Application for a Non-Material Amendment Following a Grant of Planning Permission

APP/23/00213

Revised fenestration changes (entrance door & side window position) to front elevation.

CLIENT	Mr & Mrs G Barton	DRAWING	003 Existing & Proposed Elevations
SITE	92 West Street, Havant, Hampshire	DATE	06 03 23
PROJECT	Proposed Extensions & Alterations	SCALE	1: 100 @ A3
		AUTHOR	AH
		STATUS	PL

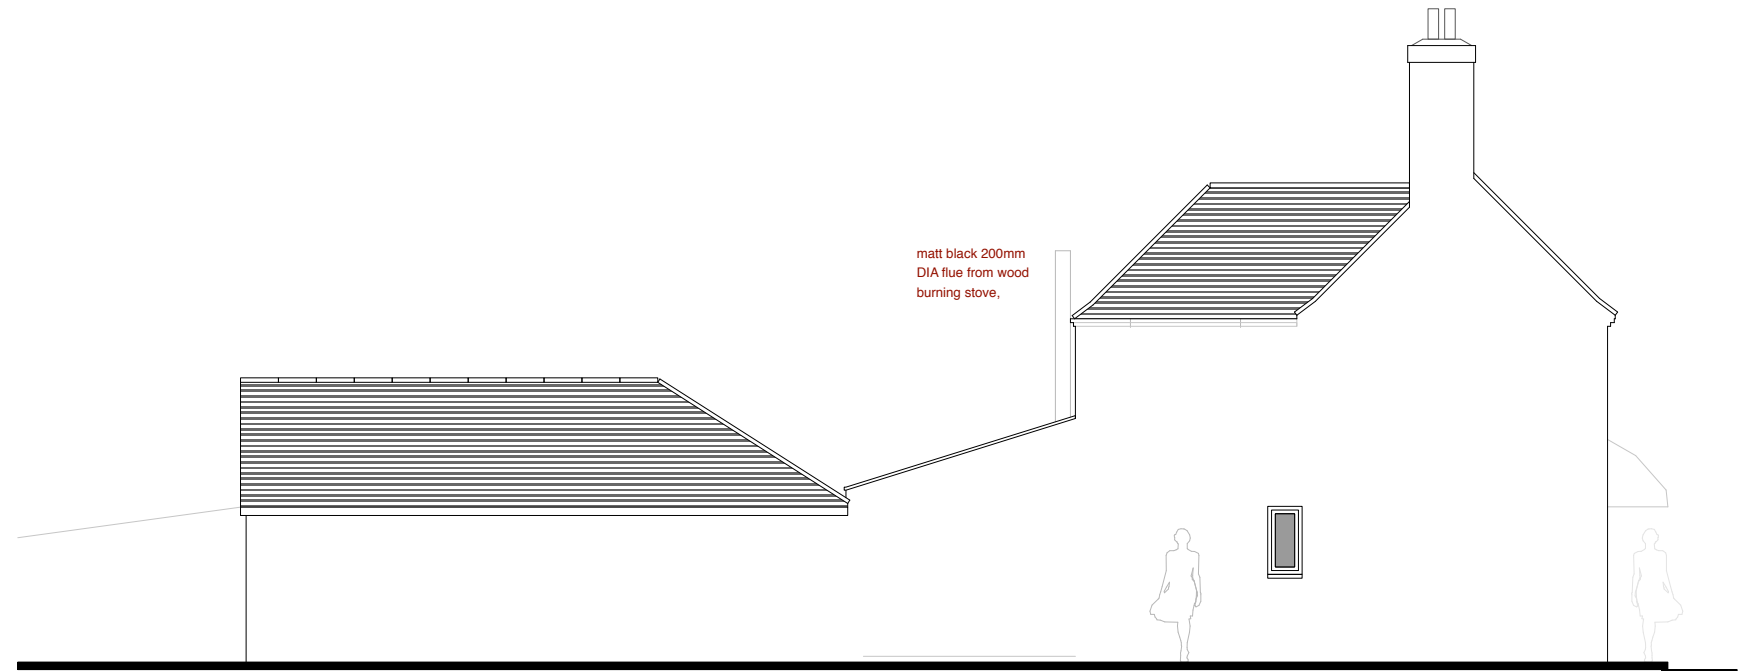
Following the applicants careful removal of render finish from the front elevation, these works have revealed an original brick header detail suggestive of a previous / historic siting of the front / entrance door. In light of these findings and in line with the approved scheme showing that the brickwork is to be left exposed, the applicants propose to reposition the door into its previous / historic location below the brick header detail. We concur that this would be a sensitive & suitable solution.
